From: Amanda Scholes on behalf of Planning.Responses
Sent: 16 August 2017 10:28
To: Planning Scanning
Subject: FW: Fitzalan Link - LU.234.16.RES - Fitz RSA1 Addendum Response Report

Subject: RE: Fitzalan Link - LU.234.16.RES - Fitz RSA1 Addendum Response Report

Thank you for your two emails dated 9th August 2017 – one with Addendum Stage 1 Road Safety Audit (August 2017, Project Code: S/PHFITZ.1.1AD.6a) – and the other, the Designer's Response (dated 8th August 2017), Addendum Safety Audit Brief (July 2017, Project Code: A/PHFITZ.1) and previous Stage 1 Audit and Designer's Response (October 2011, Project Code: WYGLITTLEHAMPTON.6A).

scale	1:2000 @ A3	drawn by	OJN	checked by	AB
date	MAY 2016	cad file	PROW-01-P3.DWG		
drawing number	PHF-MB-S278-GF-DR-D-PROW-01			rev.	P3

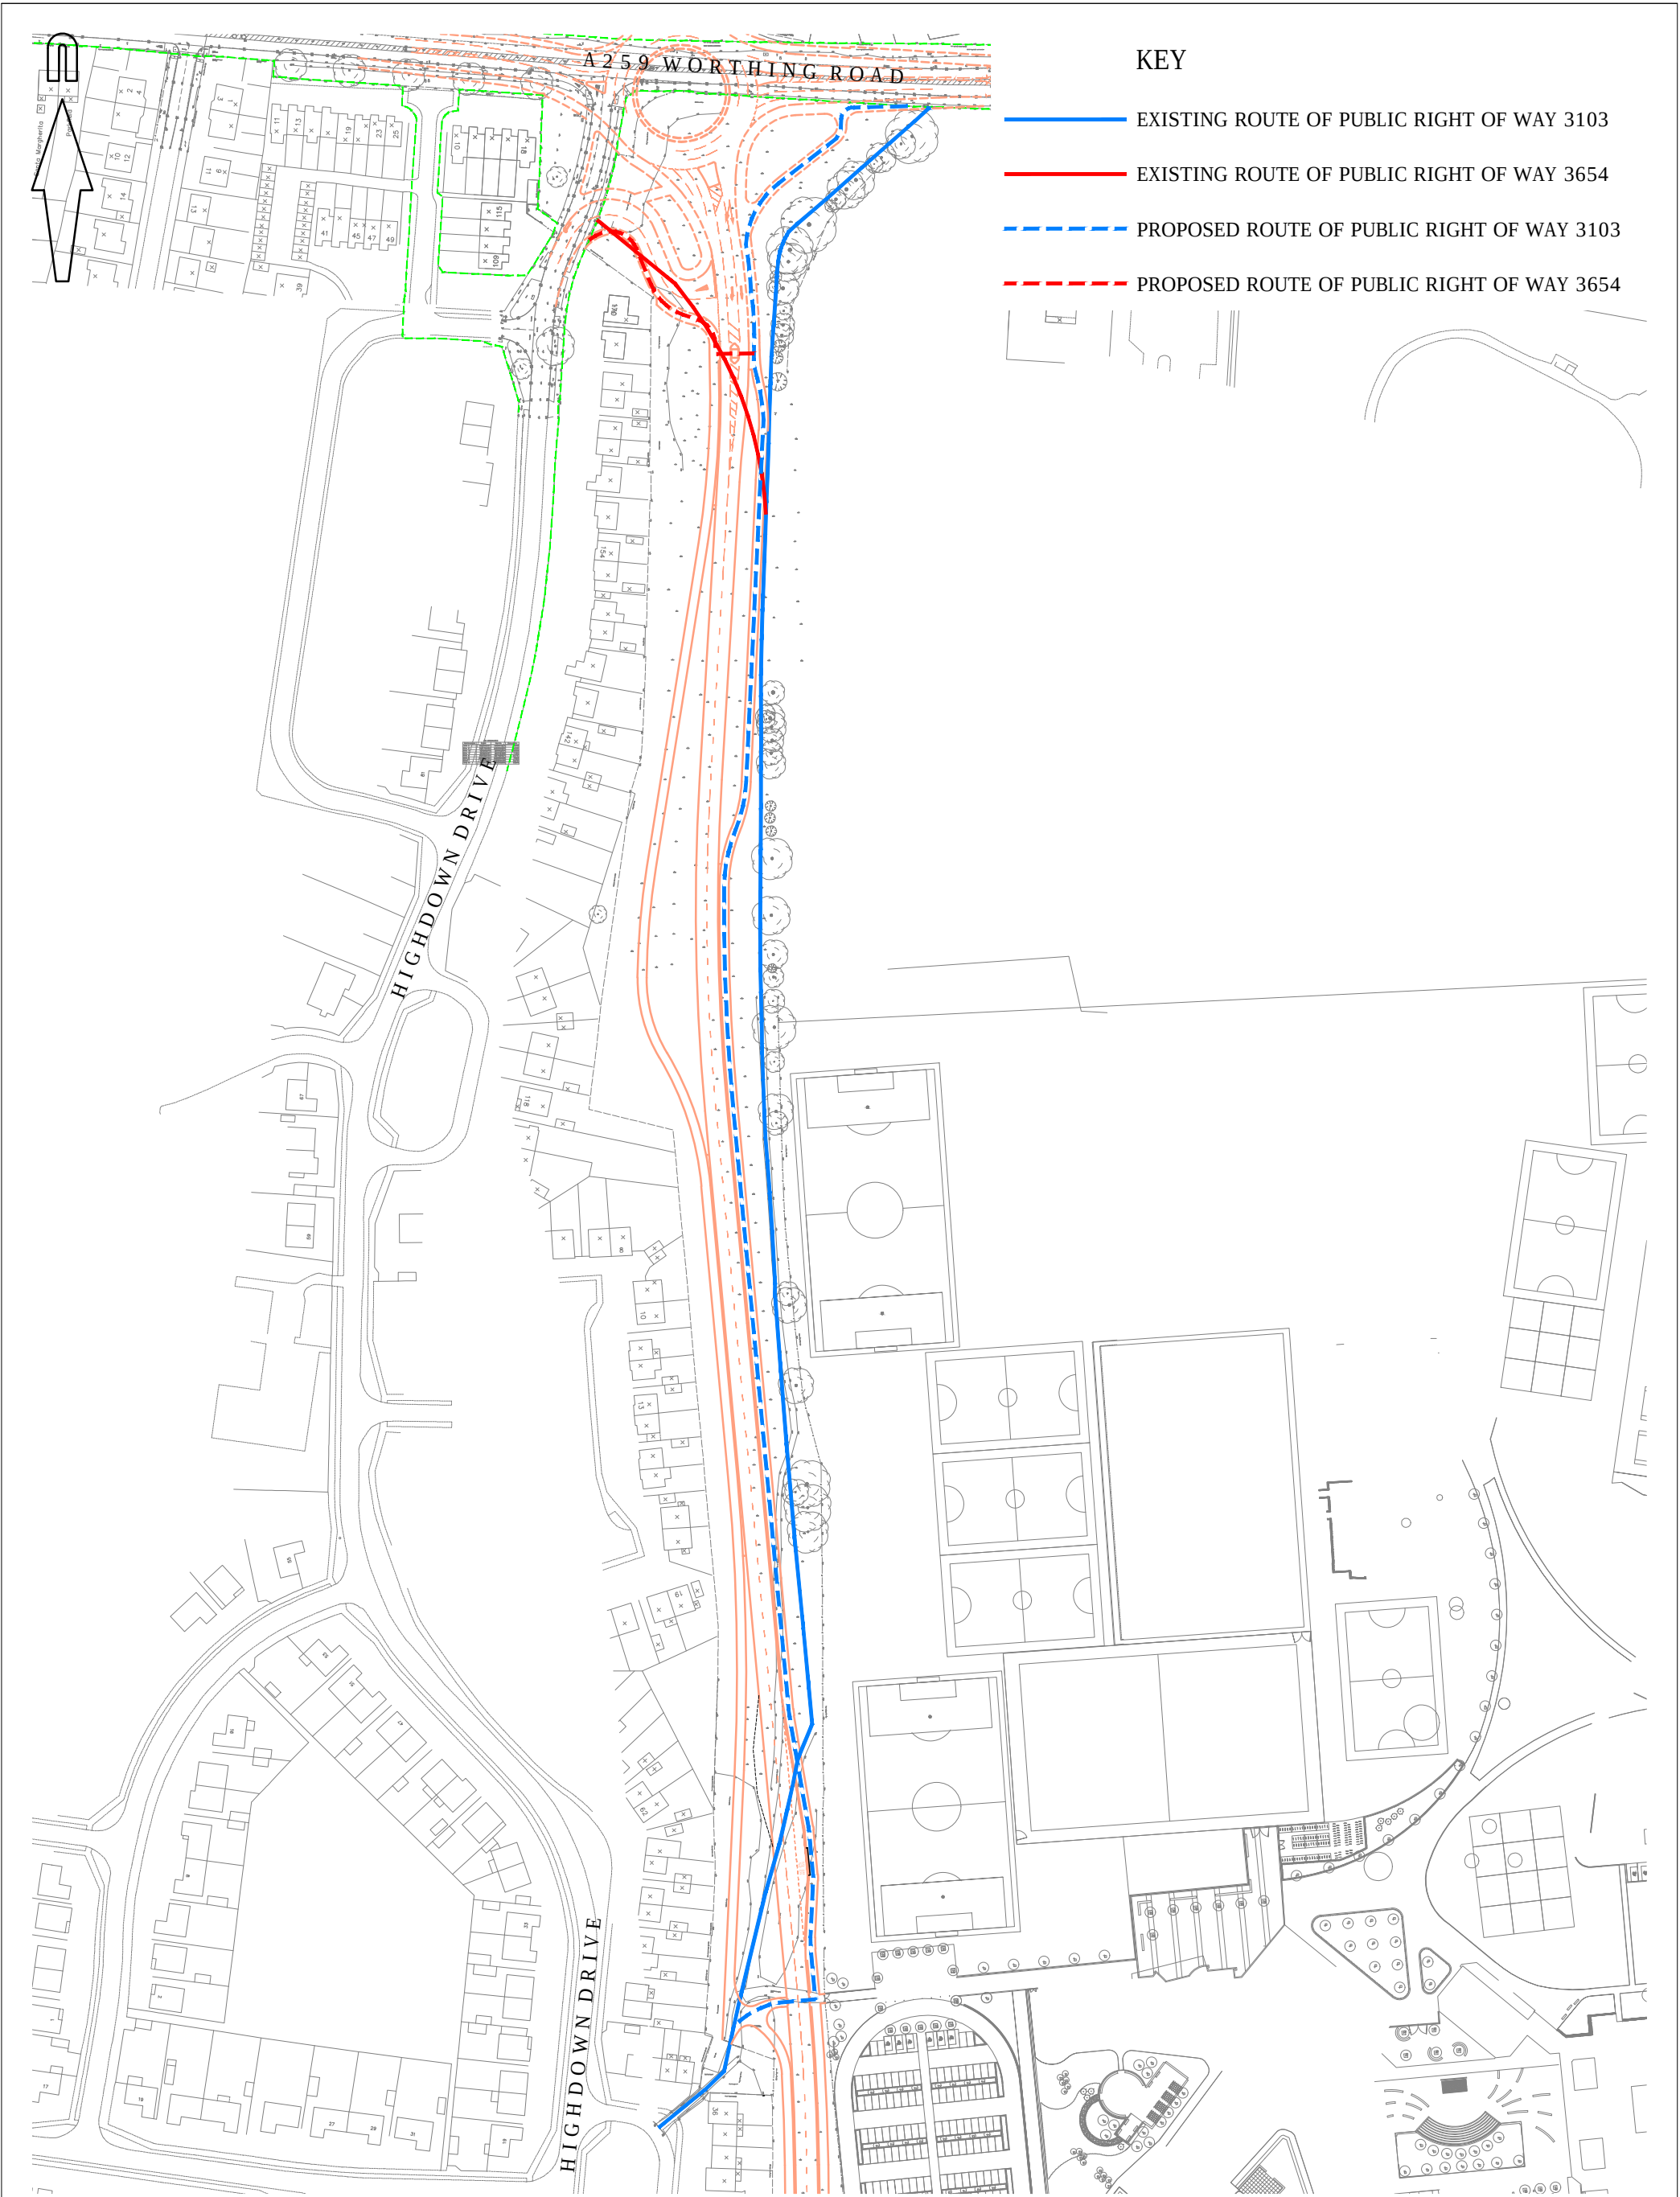
You have again offered an explanation for the path alignment in the vicinity of the Toucan crossing and balancing pond. The radii proposed are acceptable to us but the path must connect properly to the path leading to Highdown Drive which should be upgraded to a shared footway-cycleway. I have indicated below what this might look like. However, looking at this again shows the pink area to be public highway and on the line of part of Public Footpath 3103. Therefore, it is recommended (and indeed appears more straightforward) to retain this line otherwise it appears that any continuation of the route south of your scheme might cross land that might not be highway. Any path should be lit, edged, resurfaced, signed and tactile-paved appropriately although these final details can be shown at the S38/278 stage. Any upgrade from Public Footpath to shared footpath-cycleway must be undertaken in accordance with WSCC PROW procedures.

Any changes to formal PRoW (temporary and/or permanent) must only be undertaken following appropriate WSCC processes and/or procedures and obtaining all necessary permissions – some of which are often separate from any planning application processes. Full details can be obtained directly from the PRoW team here at WSCC.

The highway boundary plan and alignment of the existing PROW is noted. However, this is not evident on the ground since the Academy has been constructed (see extract from Google Earth below). We can show the alignment requested, (based on the OS Highway Boundary plans provided) but we would only have the power to construct the pathway up to our limit of ownership (the red line). WSCC has less than Freehold rights beyond the red dashed line and as such we don't believe we would have any power to undertake works on this area of land (see attached) to effect the PROW route beyond the red line, hence the reason for showing the tie-in (at the limit of ownership) to the existing physical route present on the ground. Therefore, we believe that what we have shown on the submitted drawings is the best solution, unless WSCC can confirm that we could legally obtain power to undertake works on land that they don't have complete freehold rights over. The legal line of the highway south of the Persimmon land is as shown in pink of the extract found below taken from my earlier email of 24th May 2017. As such, this is the line that should be used. As such, Persimmon should show their connection to the point shown on their boundary to ensure appropriate connection with the correct alignment. Persimmon to provide appropriate signage, lining, tactiles etc.

I have already sent a note on this. We will be submitting the diversion request under the TCPA to ADC. Once plans for the Fitzalan Link have been confirmed / approved I will start this process with relevant personnel at ADC. It is not a matter for WSCC. Noted.
